Recommendation Report for Planning Permission for Works or Extension to a Dwelling

REF NO: LY/17/18/HH

LOCATION: Calceto Barn  
Calceto Lane  
Lyminster  
BN17 7QL

PROPOSAL: New porch with hip roof & brick dwarf wall, new detached garage, new window to west elevation, new doors to south elevation, new sun tunnel for north elevation & improved drainage & low wall alteration.

PROPOSED SITE PLAN
DATE: SEPTEMBER 2018
SCALE: 1:200 @ A3
JOB No. 1040
DRWG No. 105 - Rev.

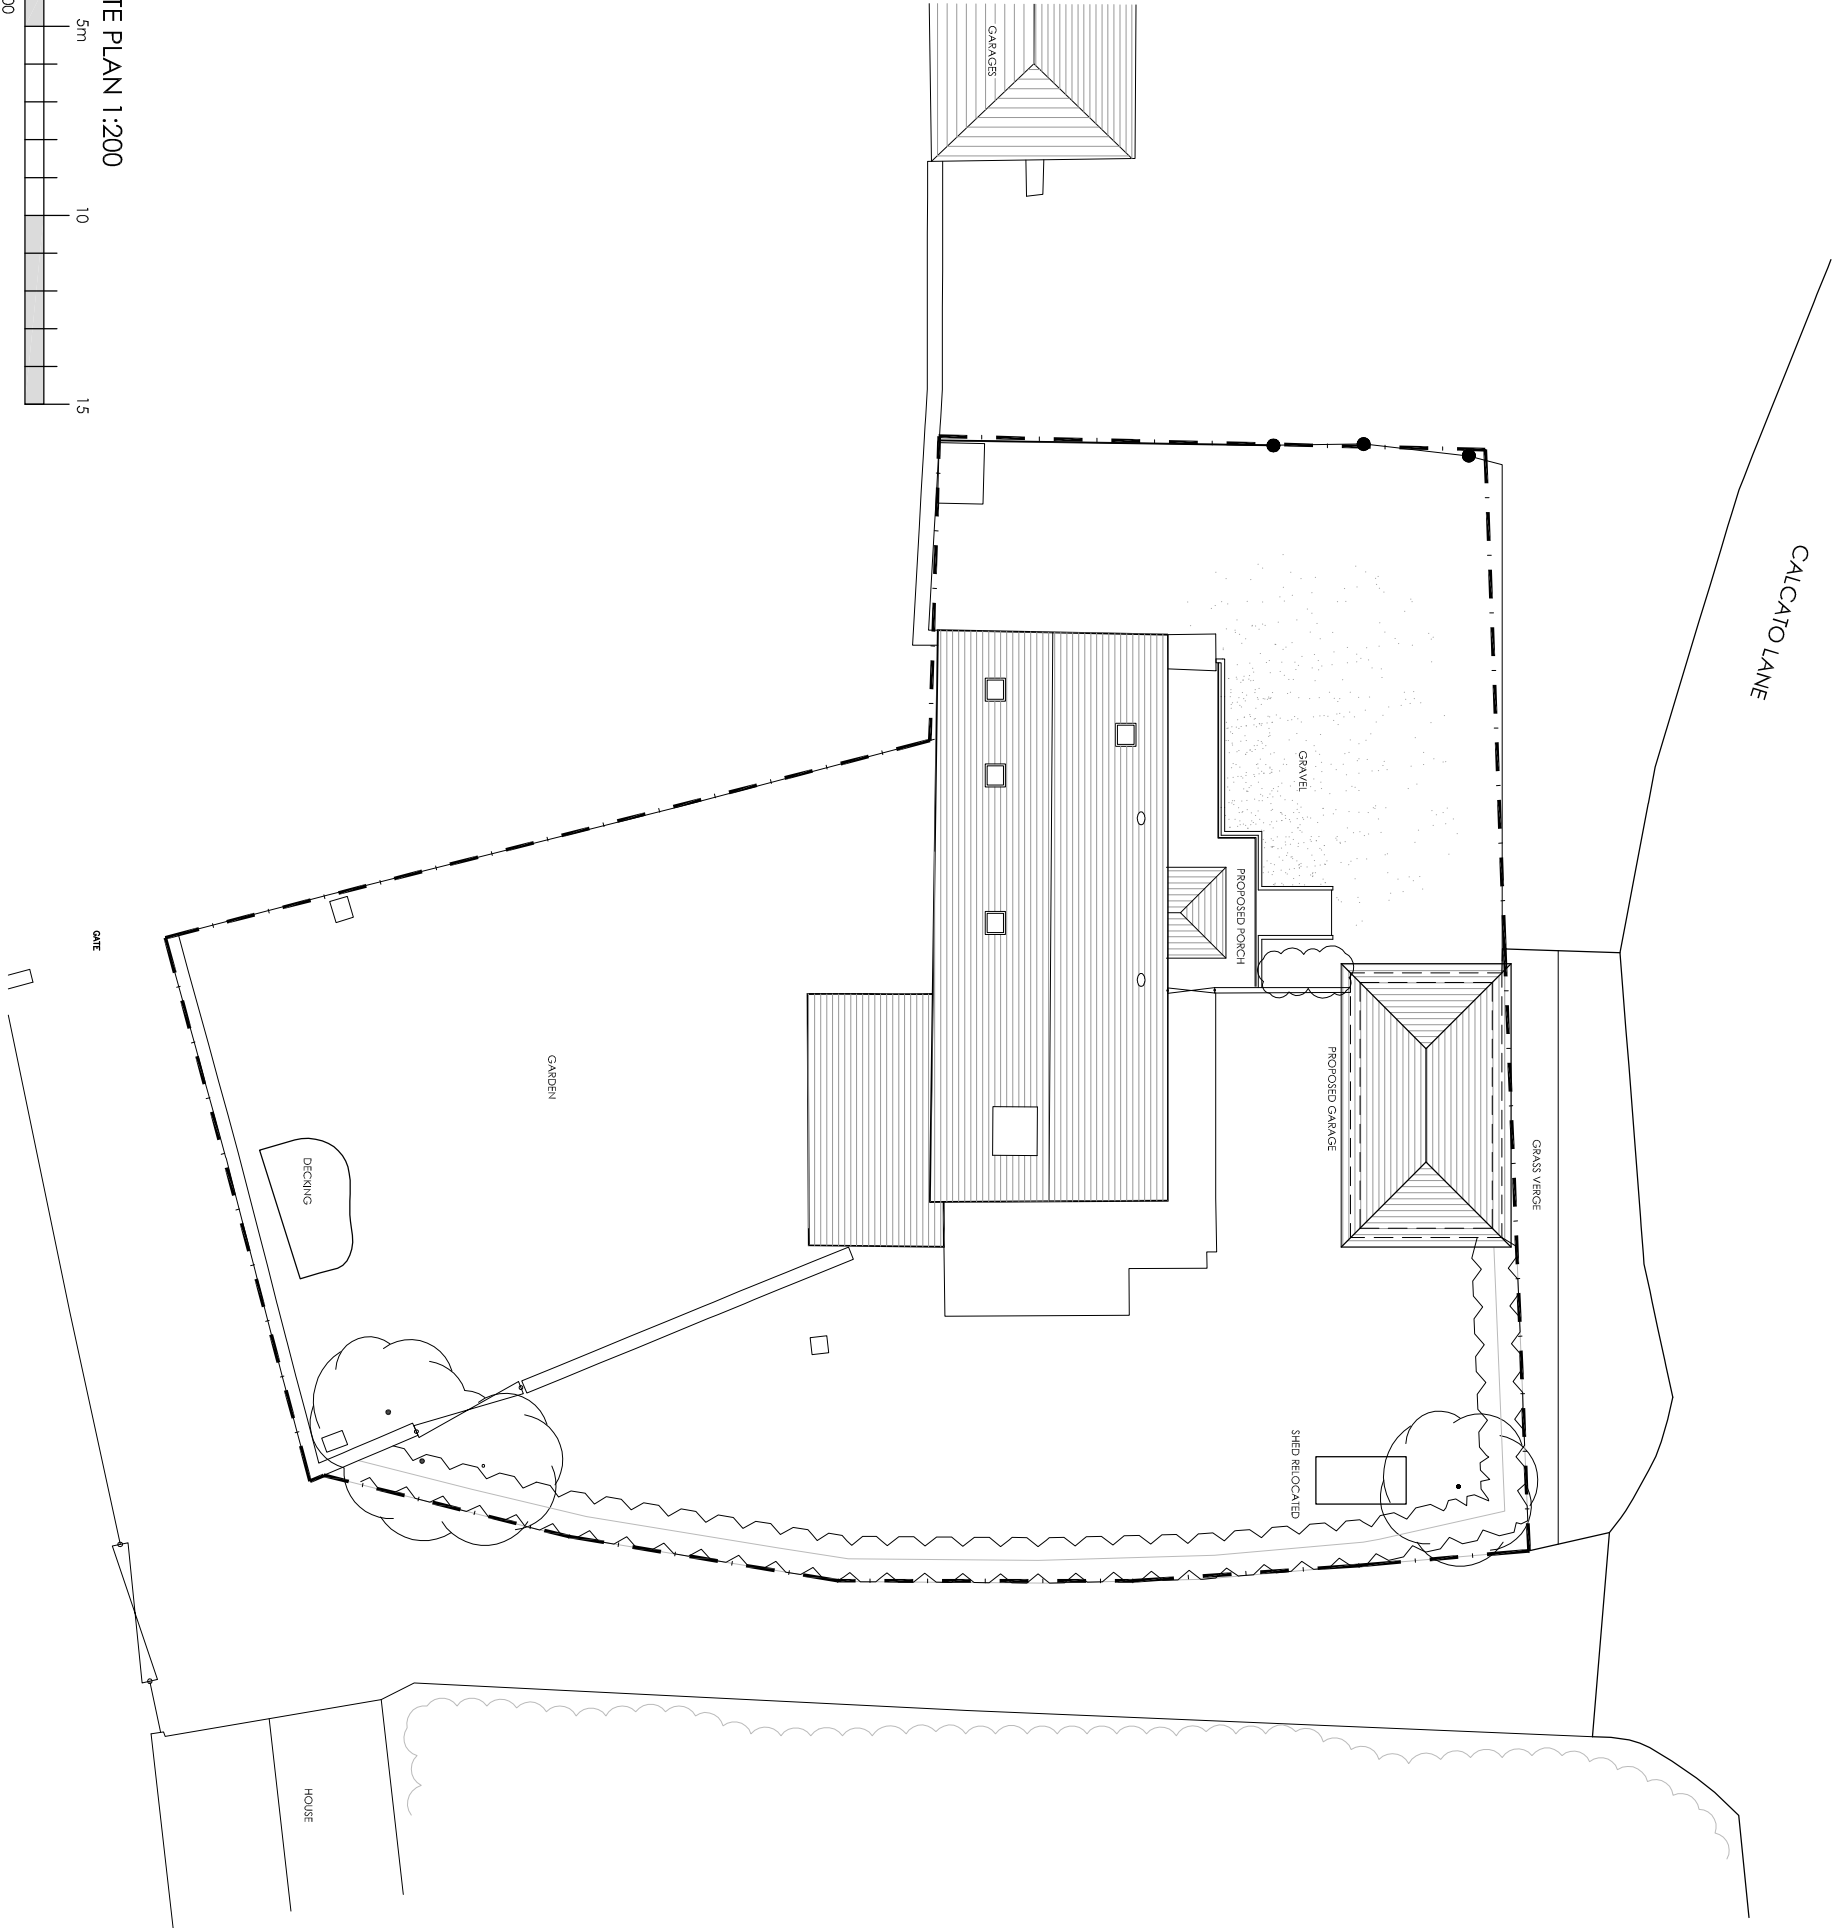
The proposed garage is considered to be an acceptable addition to the residential plot. This is because whilst it is forward of the host dwelling itself, the proposed garage is in line with the building line that has been established in the locality, especially by Connies Byre. Therefore, the garage is not deemed to have any significantly harmful impact on the established character of the locality, or the host dwelling.

The proposed development is not considered to have any significant impact on the amenities of occupiers of neighbouring dwellings. The proposed construction of the garage, and porch, are both over 10m from neighbouring dwellings. Additionally, the alterations to openings are not considered to result in any loss of privacy to adjacent occupiers.

PROPOSED ELEVATION
DATE: SEPTEMBER 2018
SCALE: 1:100 @ A3
JOB No. 1040
DRWG No. 108 - Rev.

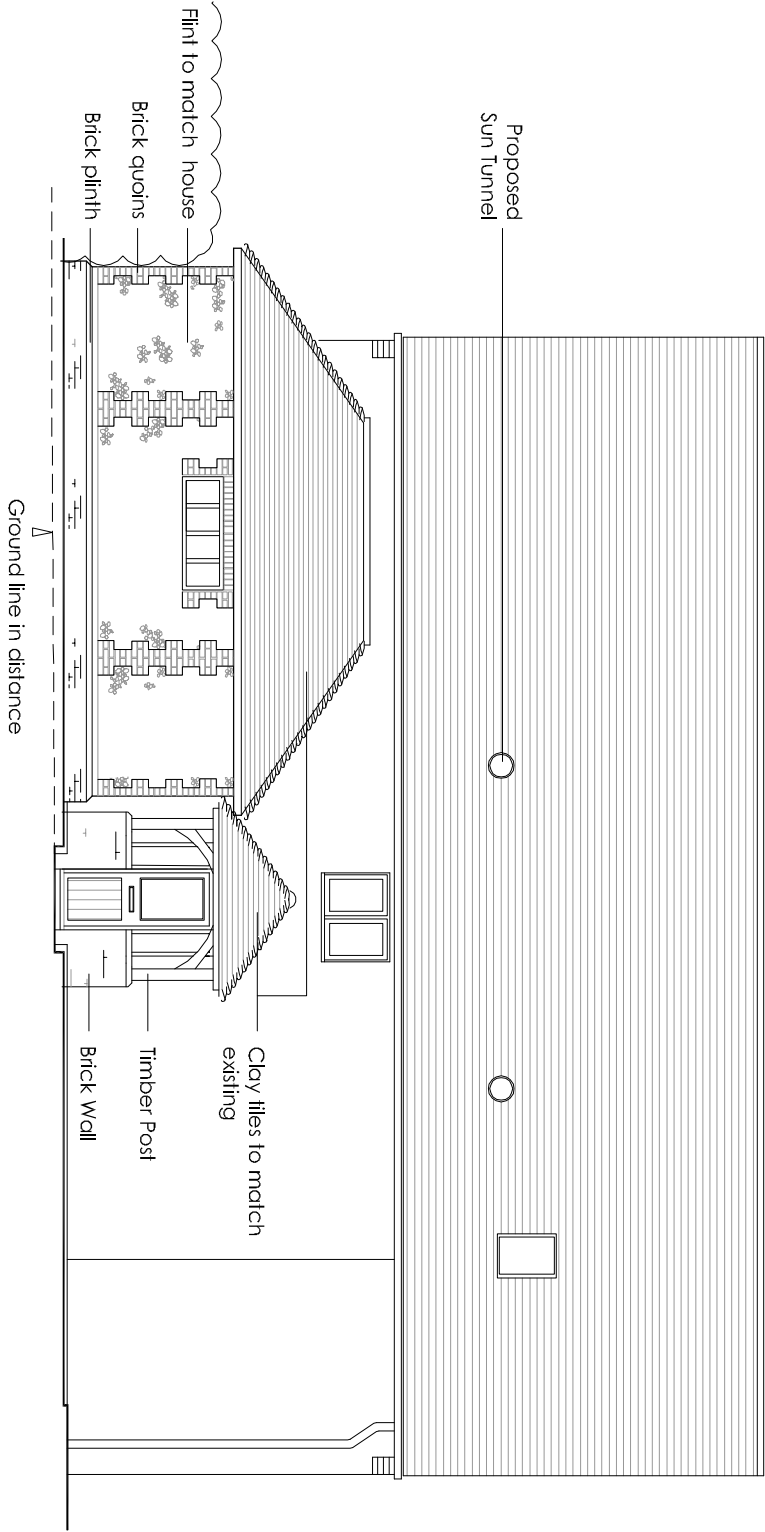
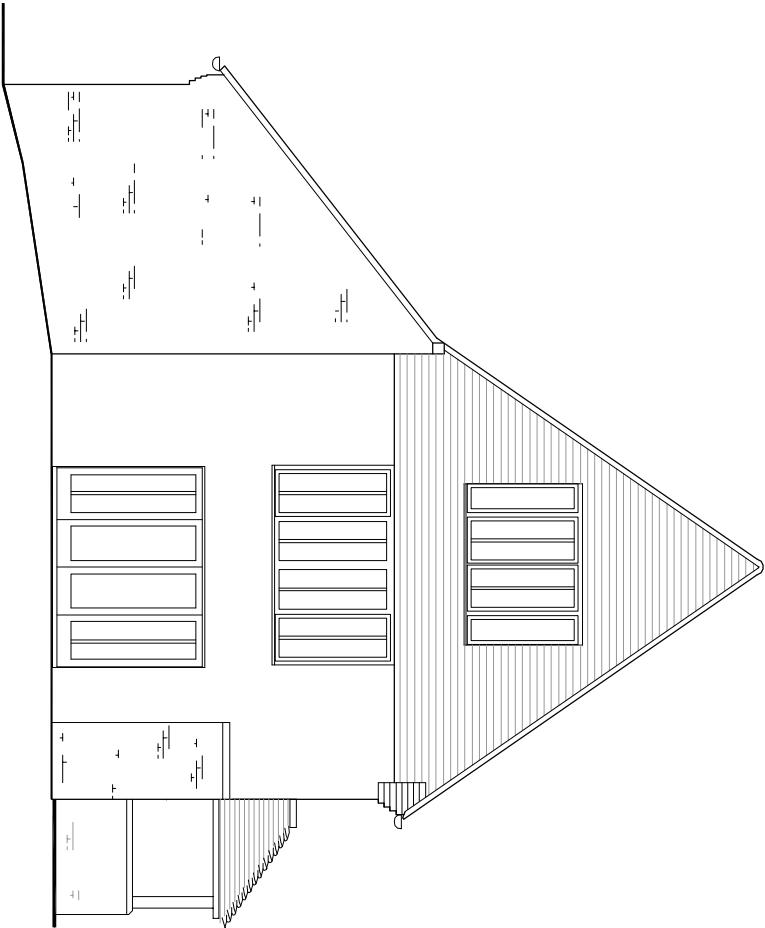
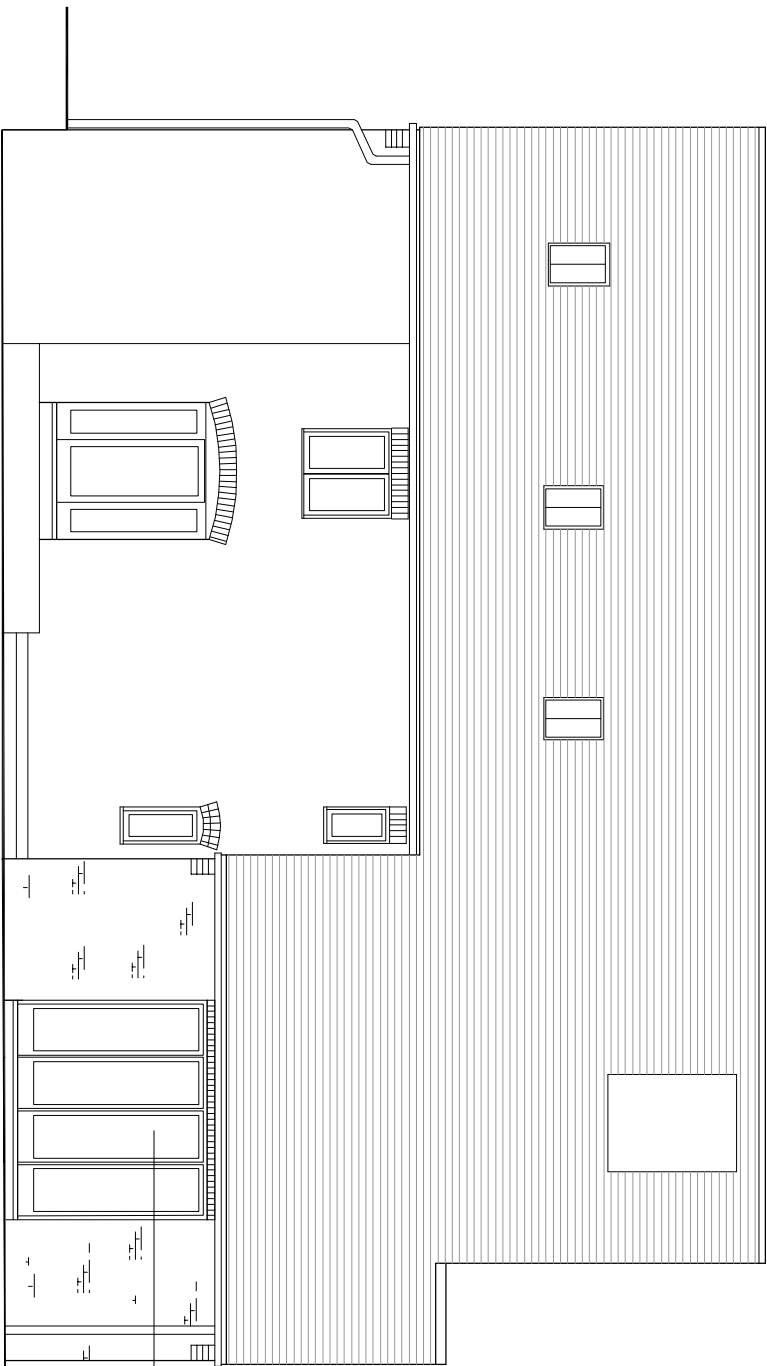
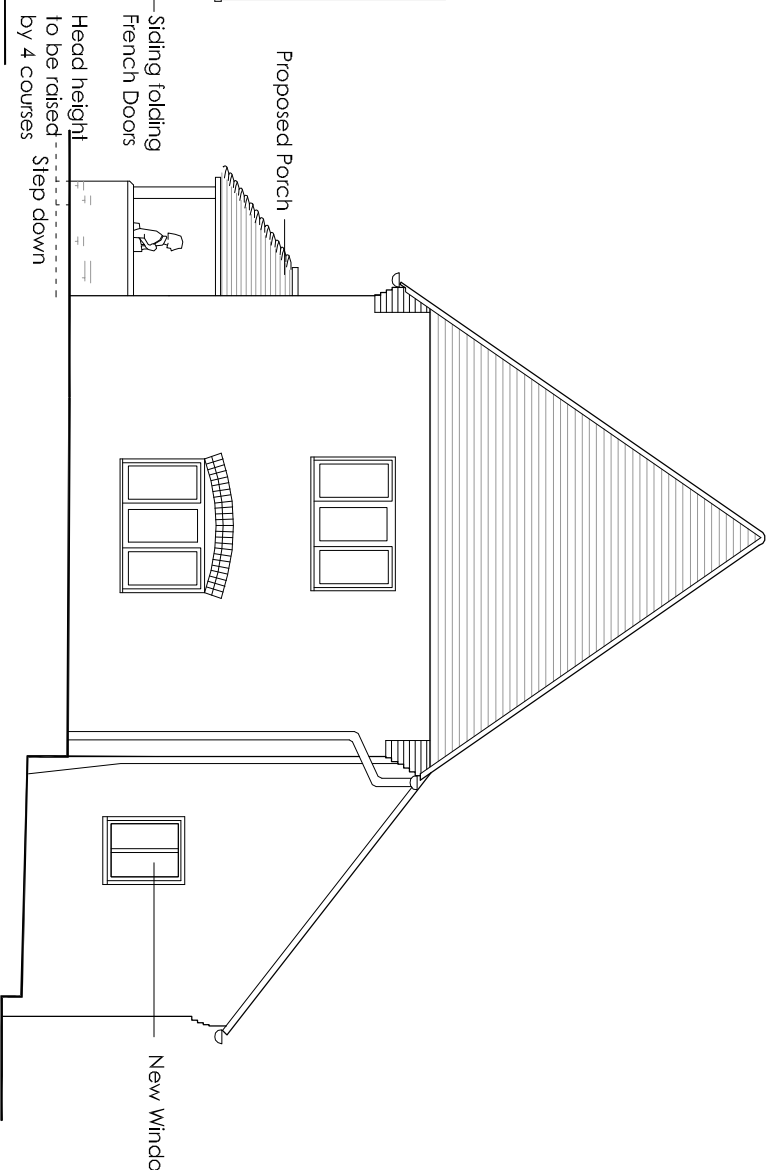
The proposed porch is visible within the street scene, as it is sited on the front of the host dwelling. However, it is considered that as a result of its modest scale and design, the proposed porch is both subservient to, and well integrated with, the host dwelling.

The proposed alterations to fenestration and layout are not considered to have any significant impact upon the character of the host dwelling, as a result of their minor impact on the appearance of the dwelling.
